RE: 49 Hanover St. (033 C009)

This office has reviewed your request dated 8/27/02, with regard to the fire separation distance for the proposed construction of a three unit building at the above location. The following are the facts:

SHEET TITLE:  
ELEVATIONS

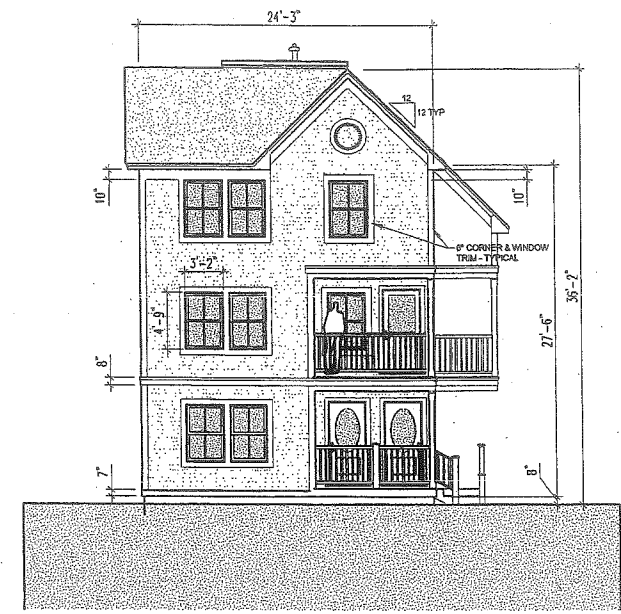
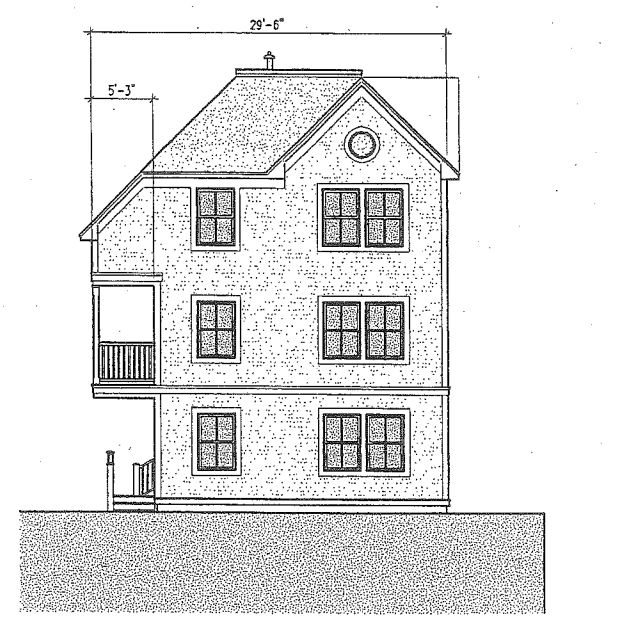
- 1) The adjacent parcel is City owned, currently occupied by the Public Works department.
- 2) There is no existing development in the current required 10 foot setback on the abutting parcel.
- 3) The proposed structure is 9 inches from this property line, which is allowable under the R7 Overlay Zone.
- 4) The proposed structure is an R3 use group, Type 5B construction with an NFPA 13D fire suppressions system that will be modified along the north side of the structure to meet NFPA 13 standards.
- 5) The proposal includes 15% glazing on the North wall.

The applicant proposes that the City measure the fire separation distance to a line that is one half the distance from the proposed structure to the setback point of the abutting property, much like the code requires for development of multiple buildings on the same lot. This distance is 5 feet 4 ½ inches. Based on the above facts the City of Portland hereby grants the request based on the limitation in openings and the upgraded fire suppression system.
